Department of
Primary Industries

Proposed modification to marine refuelling and supply facility, Berth 6 White Bay, Balmain (MP 06_0037 MOD 4)

Comment by NSW Office of Water

scale	date	revision	project no.
1:100	JUNE 2013	A	839
project	WHITE BAY 6 MARINE PARK		sheet
			00

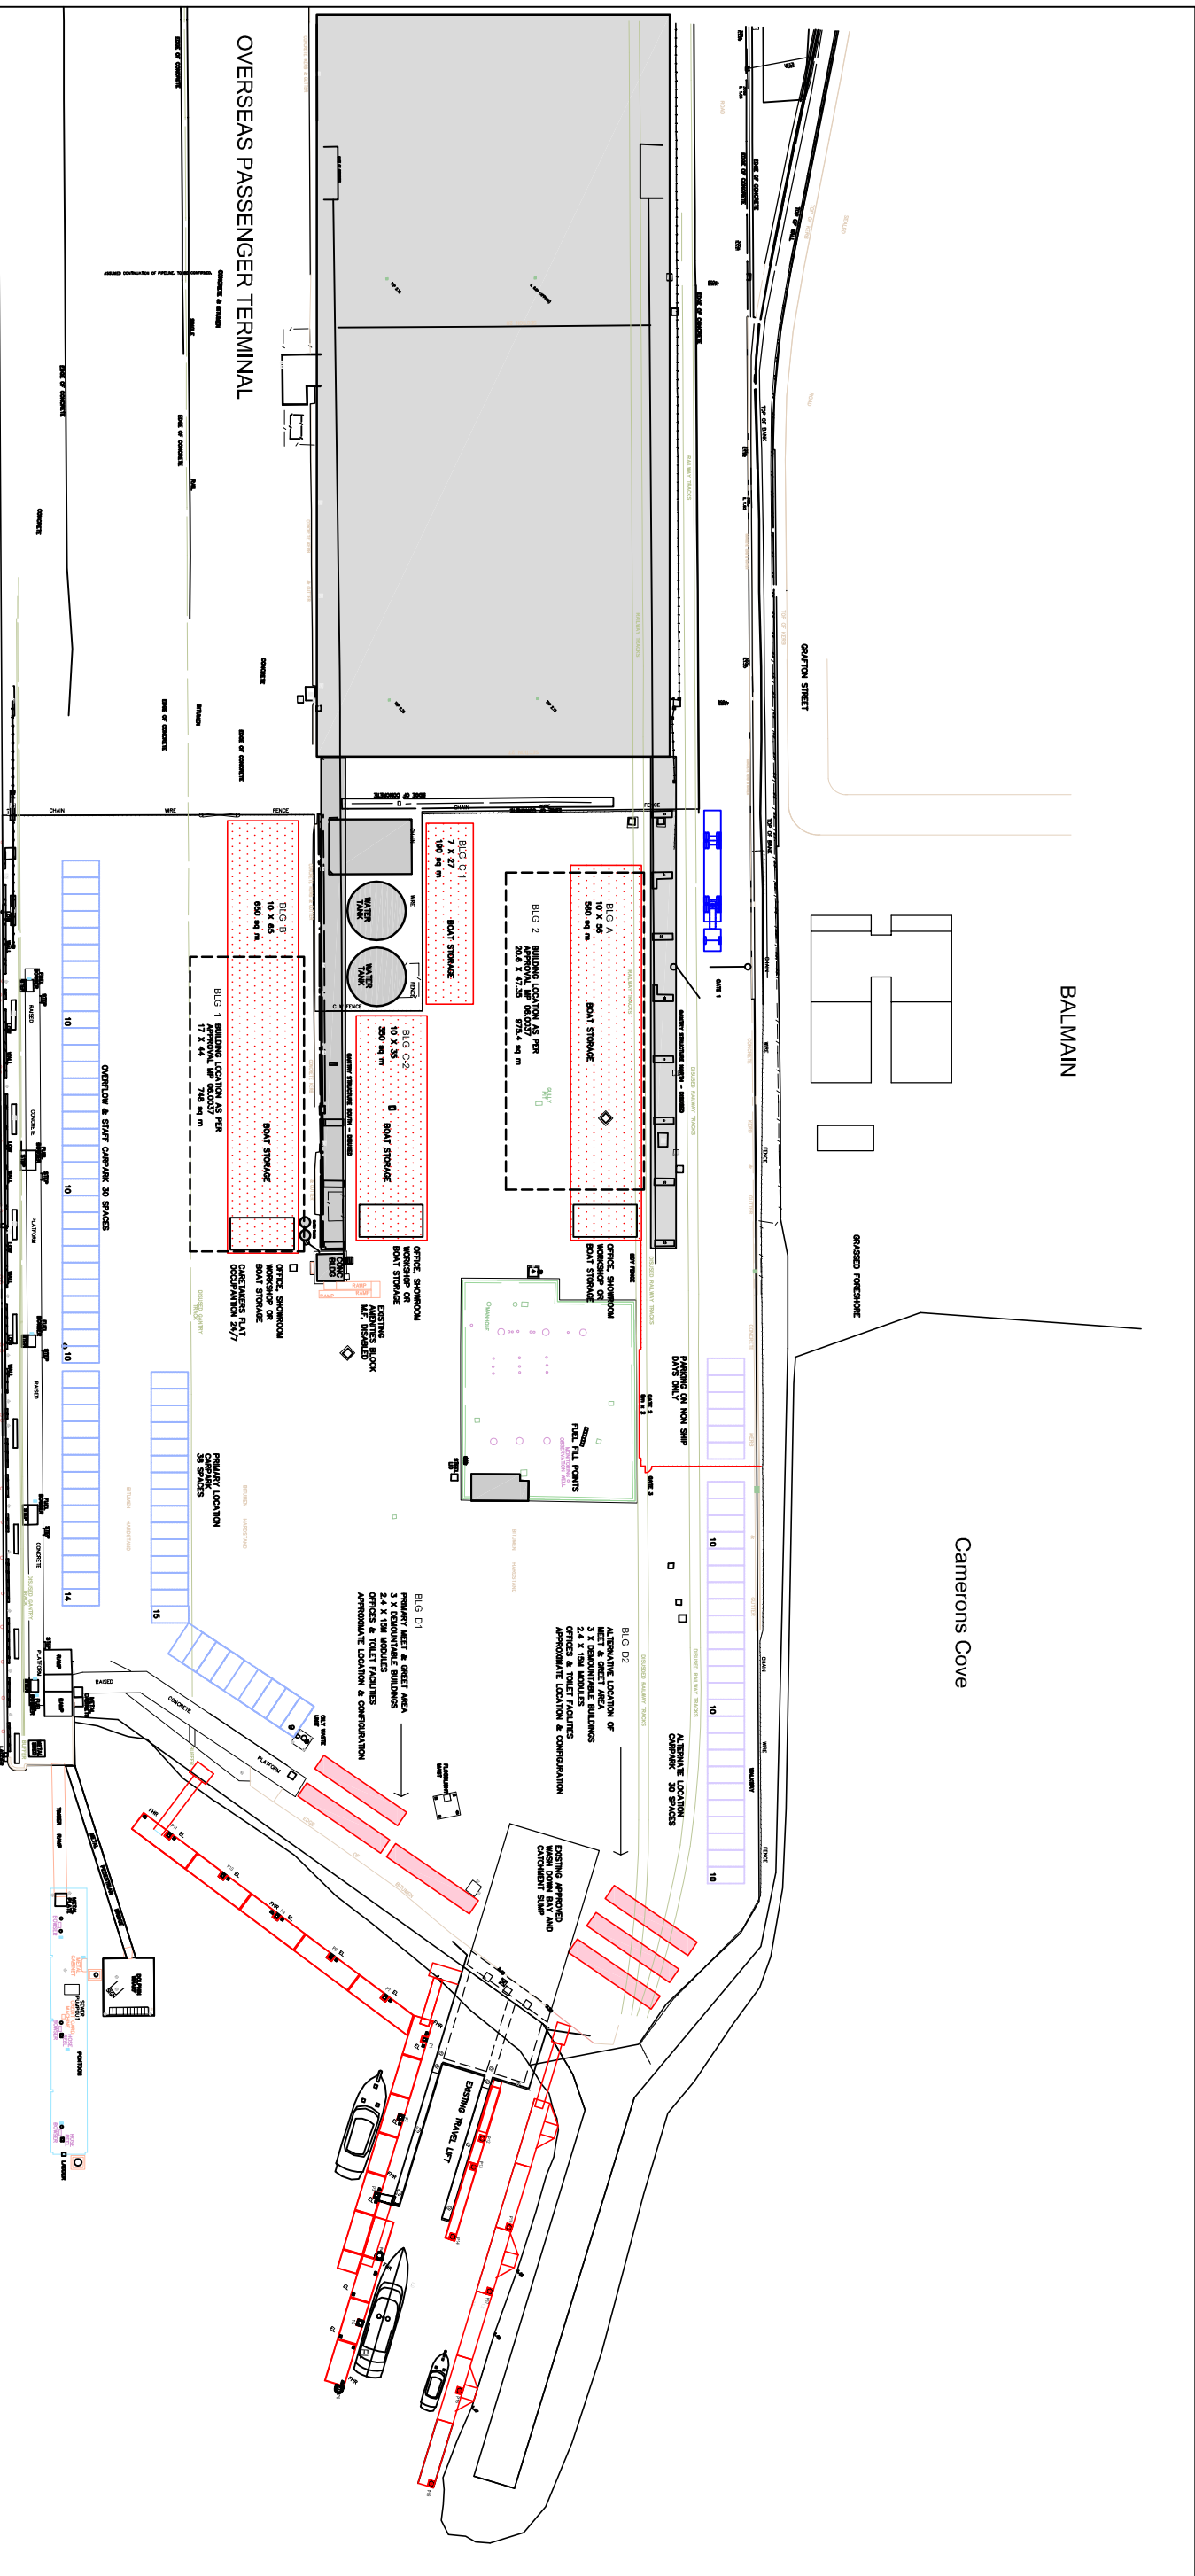
However, although outside the administration of the Office of Water, it is noted that item No. L2 in Appendix D indicates the modification includes landscape planting adjacent to the water's edge in the north western corner of the site and makes reference to Figure 1 in the Modification document. Based on the information in Figure 1 it is unclear where the landscape planting is proposed to be located, the width of this planting, nor any specific detail of the type of planting that will take place. The Office of Water suggests that the proposal would be strengthened if this was clarified.
